REQUEST	Current Zoning: R-17MF, multi-family residential and I-1, light industrial and NCDOT right-of-way to be abandoned Proposed Zoning: BD(CD), distributive business, conditional
LOCATION	Approximately 4.18 acres located on the west side of Statesville Road between Twin Lakes Parkway and Future Interstate 485.
CENTER, CORRIDOR OR WEDGE	Corridor
SUMMARY OF PETITION	This petition proposes a four story, 119 room hotel, with a maximum of 68,000 square feet. The petition seeks to abandon and establish zoning for 1.62 acres of right-of-way along the old alignment of Statesville Road. The potential abandonment area has been included in the rezoning petition.
STAFF RECOMMENDATION	Staff recommends approval of this petition upon resolution of outstanding issues. The petition is consistent with the <i>Northlake Area Plan</i> .
Property Owner	Malcolm B. and Frances A. Blankenship, and NCDOT
Petitioner	Sherpa Land Company, LLC

PLANNING STAFF REVIEW

C1.0

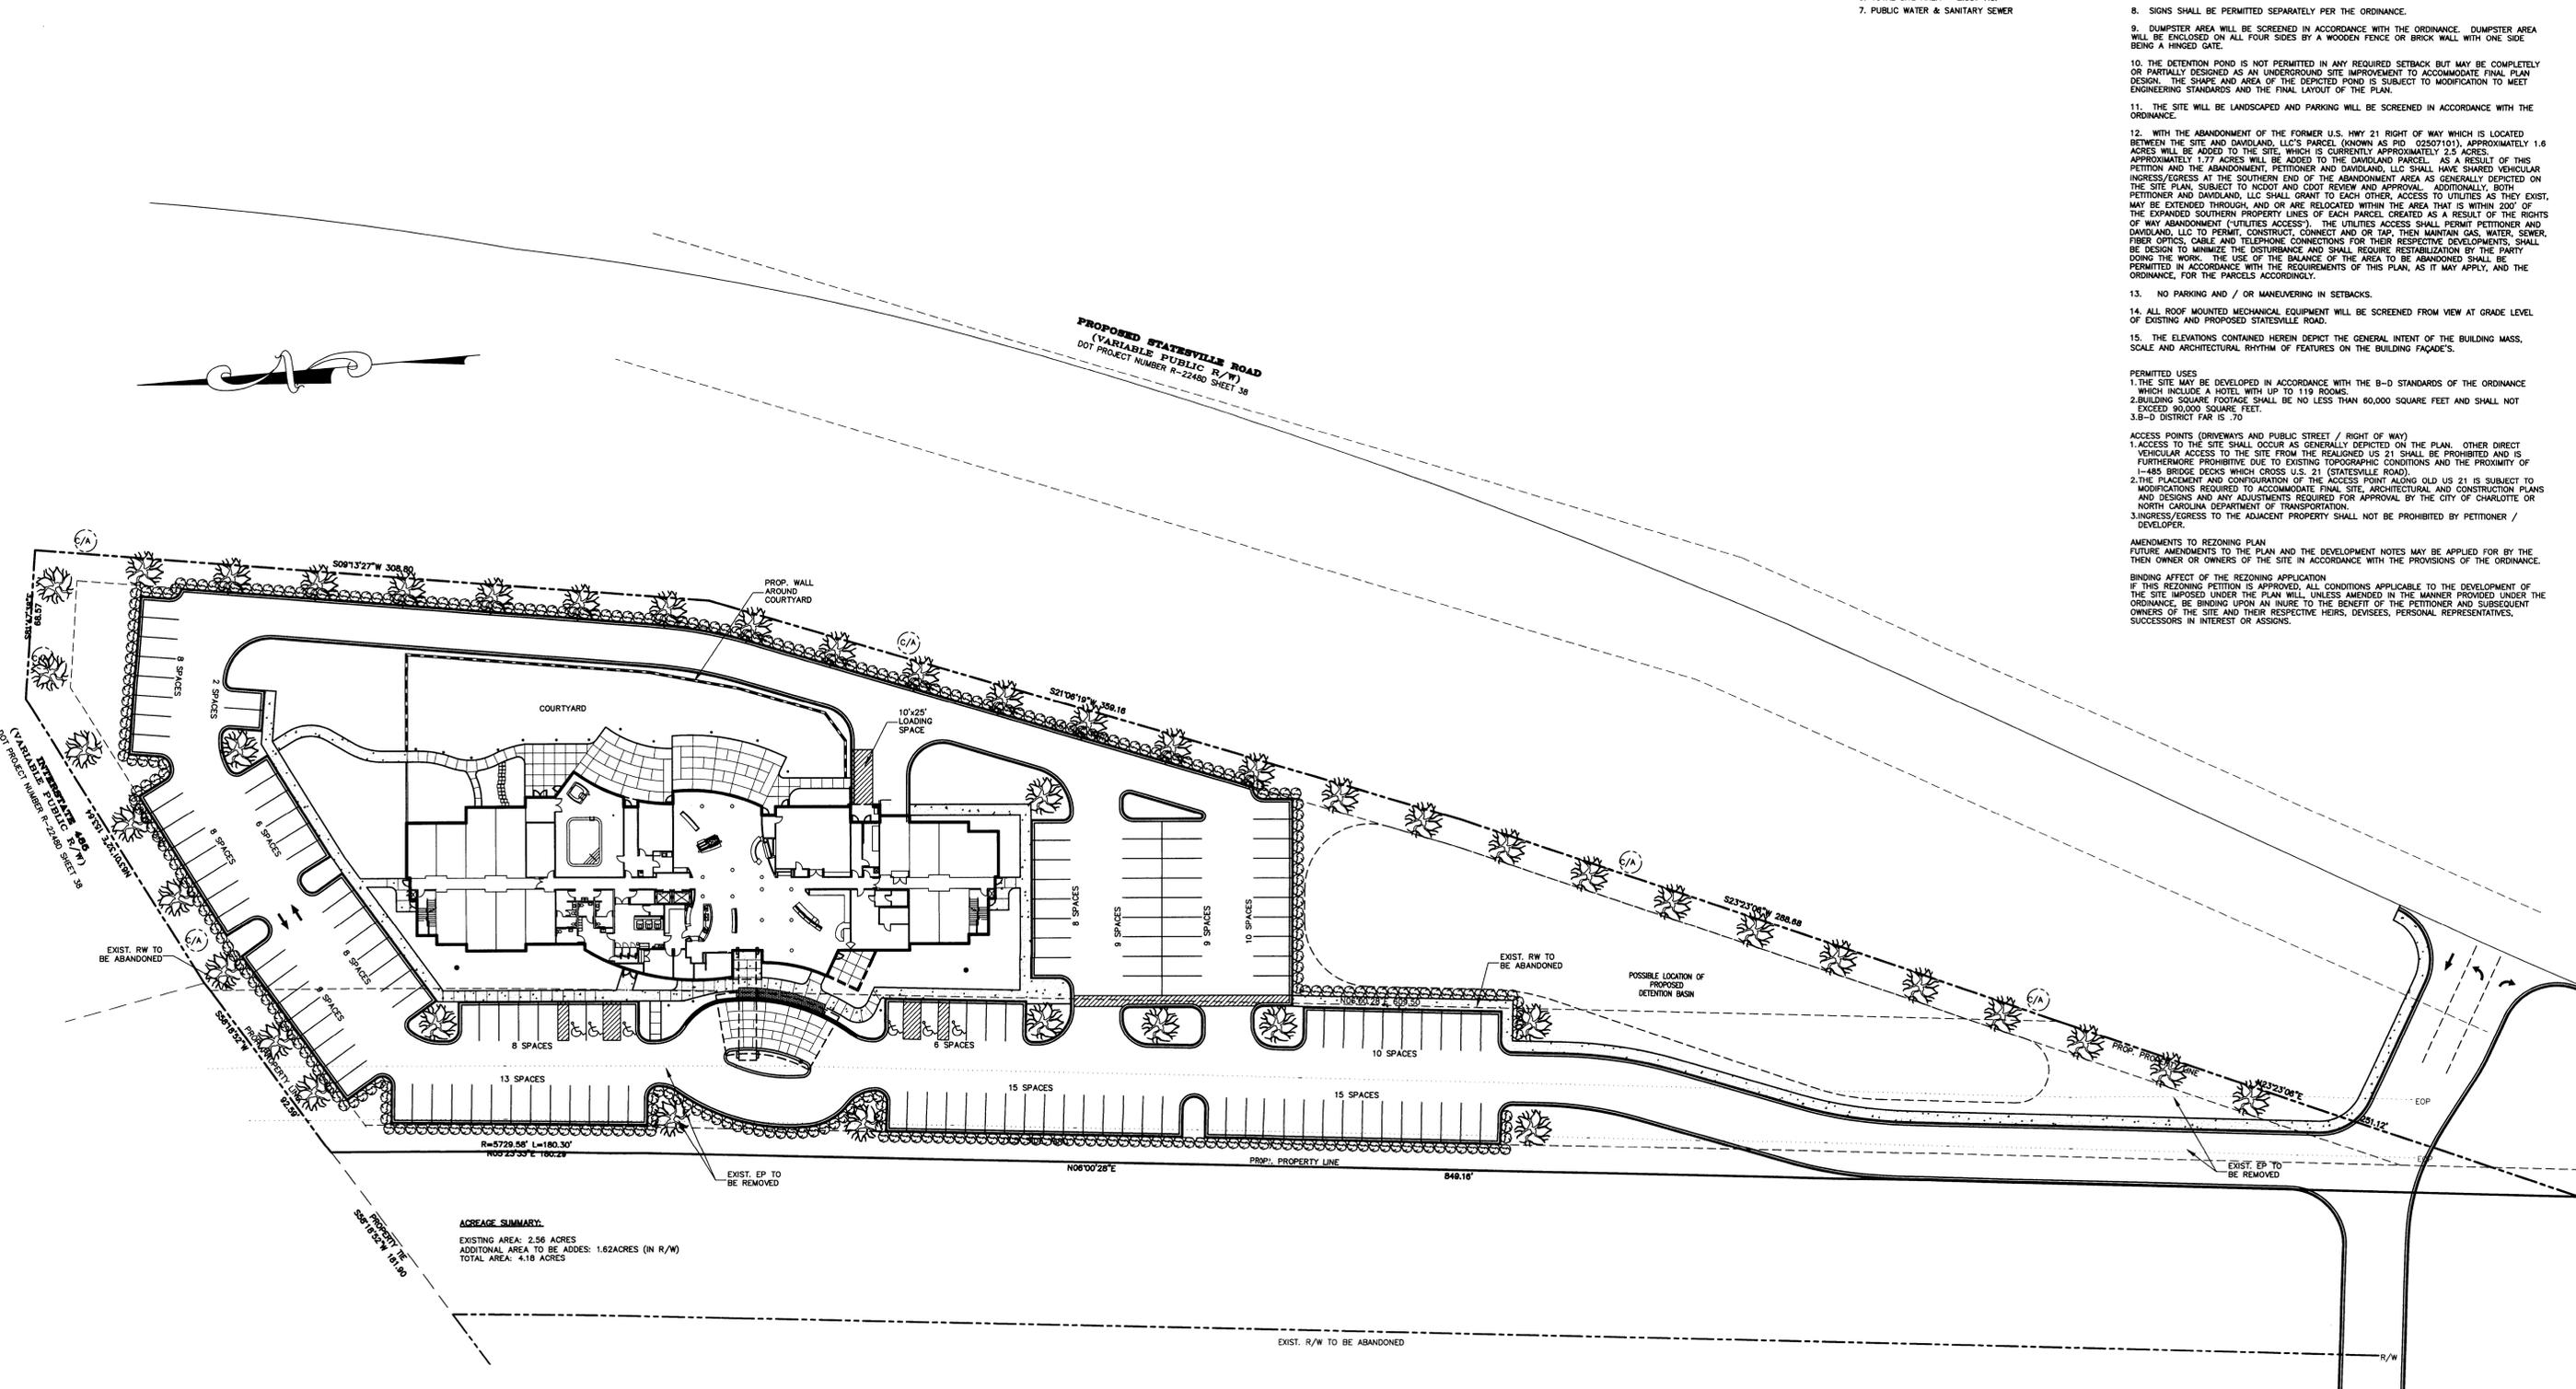
- The petitioner should:
 1. Label the setbacks along Interstate 485 and the new alignment of Statesville Road.
 2. Show dumpster location.
 3. Indicate total site area as 4.18 acres.
 4. Correct maximum square footage discrepancy as noted under Project Data and Note 2 under Permitted Uses.
 5. Specify actual floor area ratio.
 6. Add a note that the petitioner will submit a Solid Waste Management Plan prior to initiating land clearing, demolition and/or construction activities.
 7. Specify the width of all sidewalks.
 8. Label all streets.
-
